DECISION DELEGATED TO HEAD OF PLANNING

Application No: H02-0593-26 **Applicant:** Mr M Woodroffe
Proposal: Erection of Single-Storey Extension and Car Port
Location: 15 Barbers Drove South Crowland
Terminal Date: 25th August 2026

Proposed Plan and Elevations

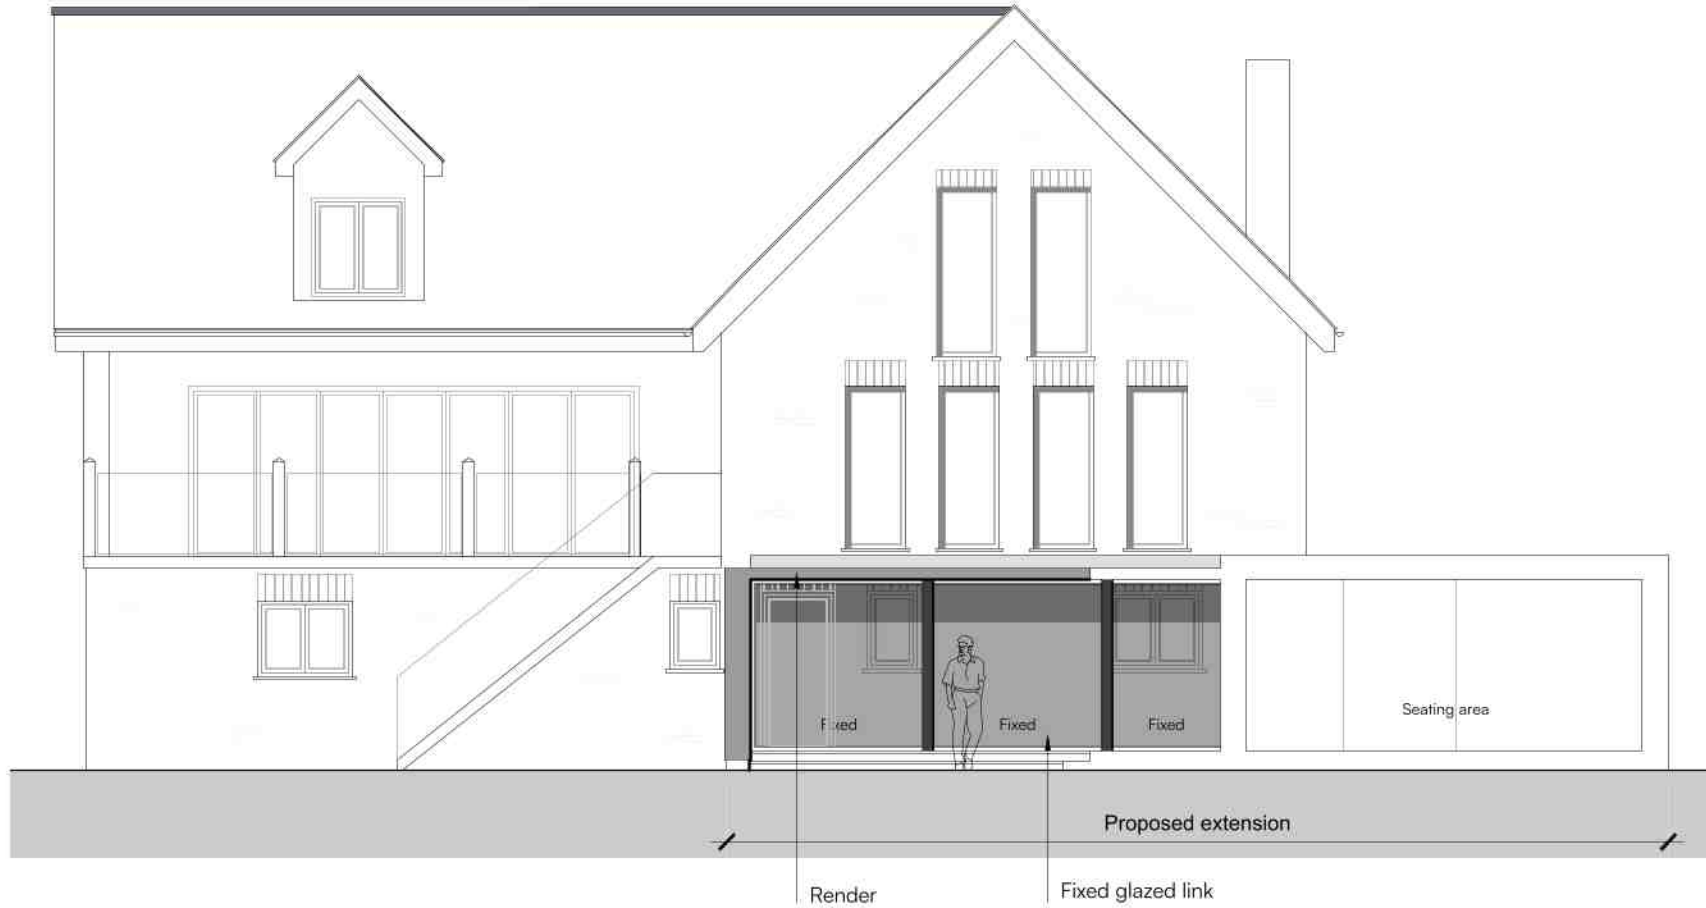
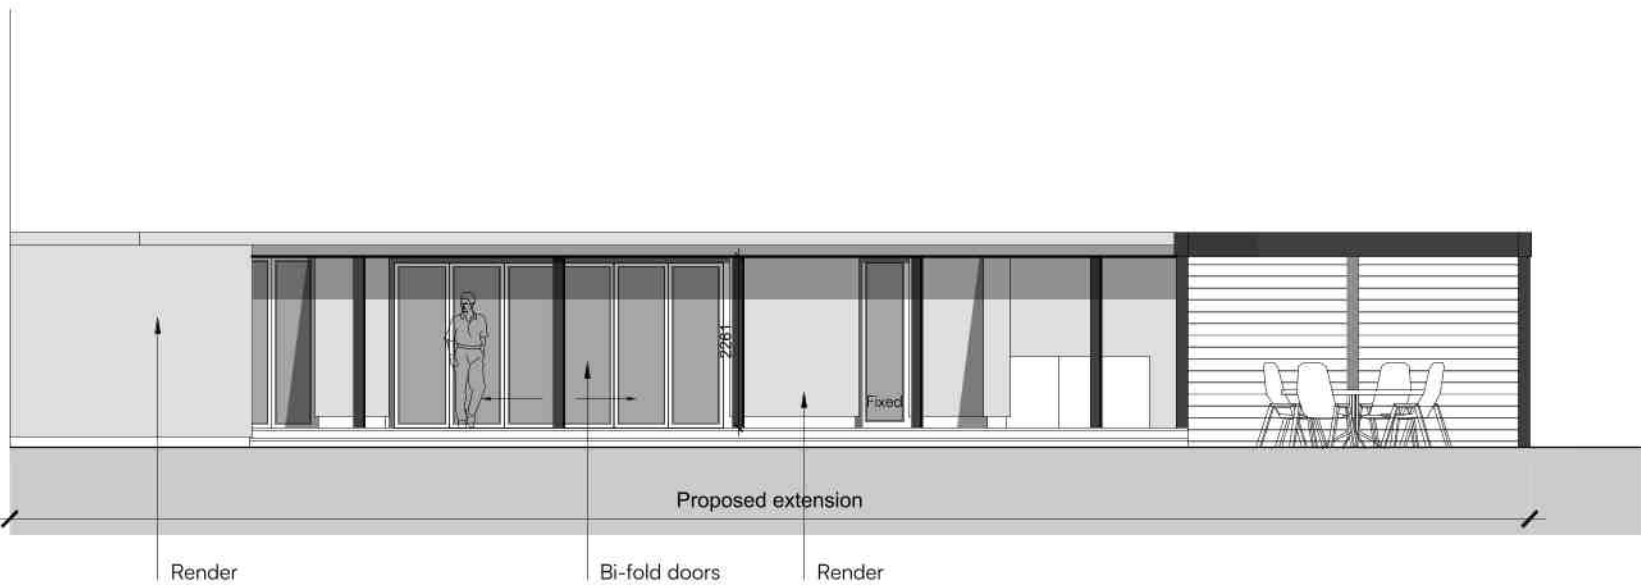
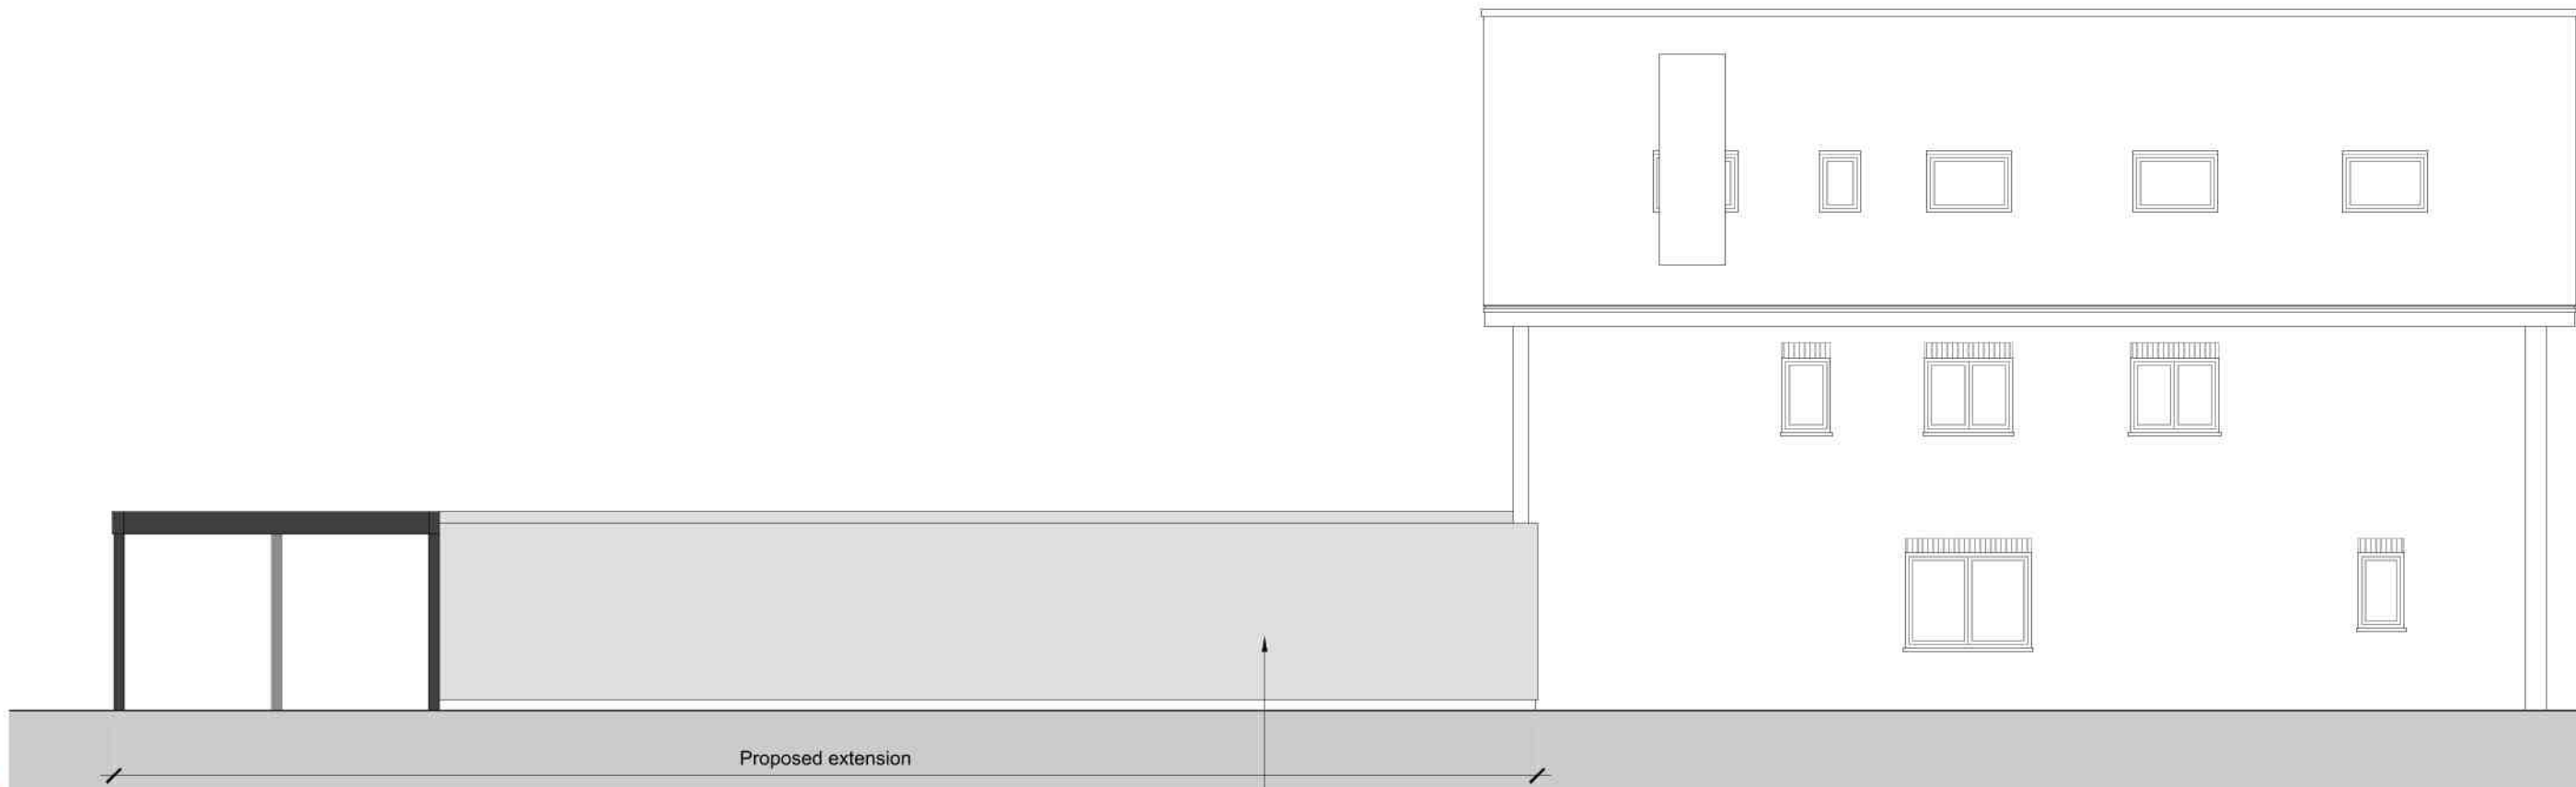
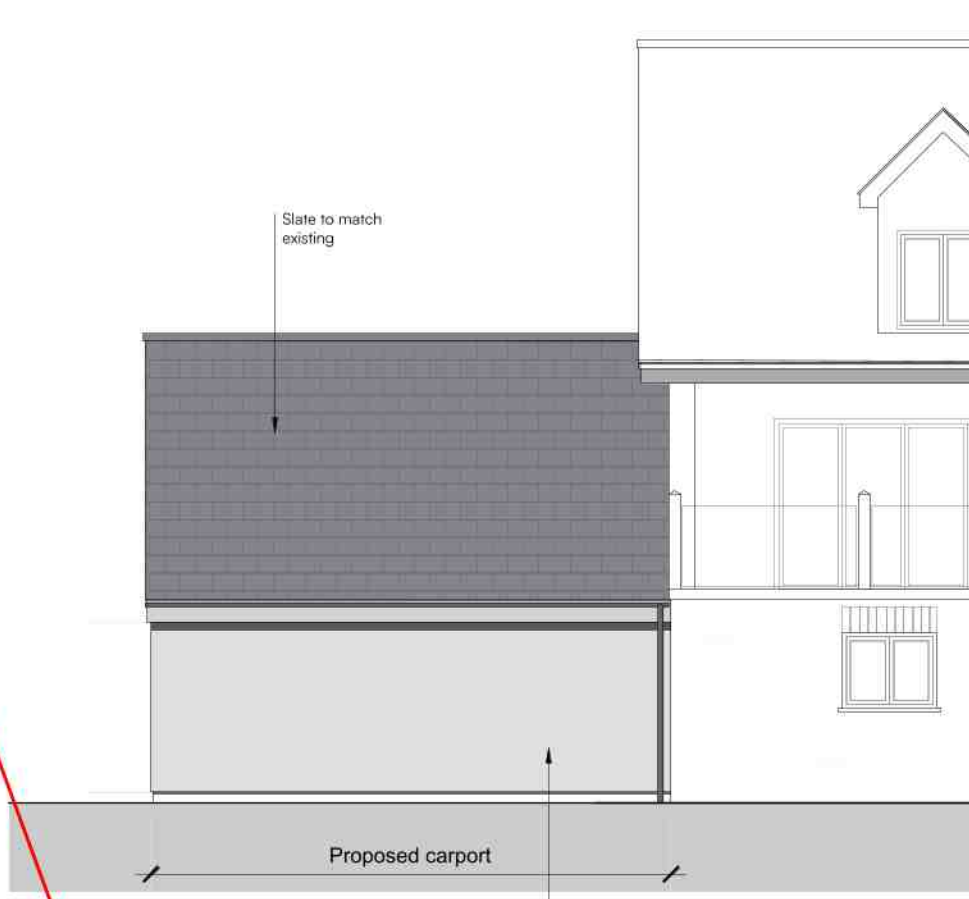
The dwelling currently features gable end roof forms and as set out previously, the roof form of the proposed car port was amended during the determination of the application to a gable end roof form to correspond with the host dwelling. Initially, a flat roof form was proposed for the carport and it was considered that this would have jarred with the host dwelling. The revised roof form is considered to be acceptable on balance. Although the ridgeline is relatively tall for a side extension, the overall dwelling is relatively tall and the roof pitch of the car port matches the roof pitch of the existing dwelling.
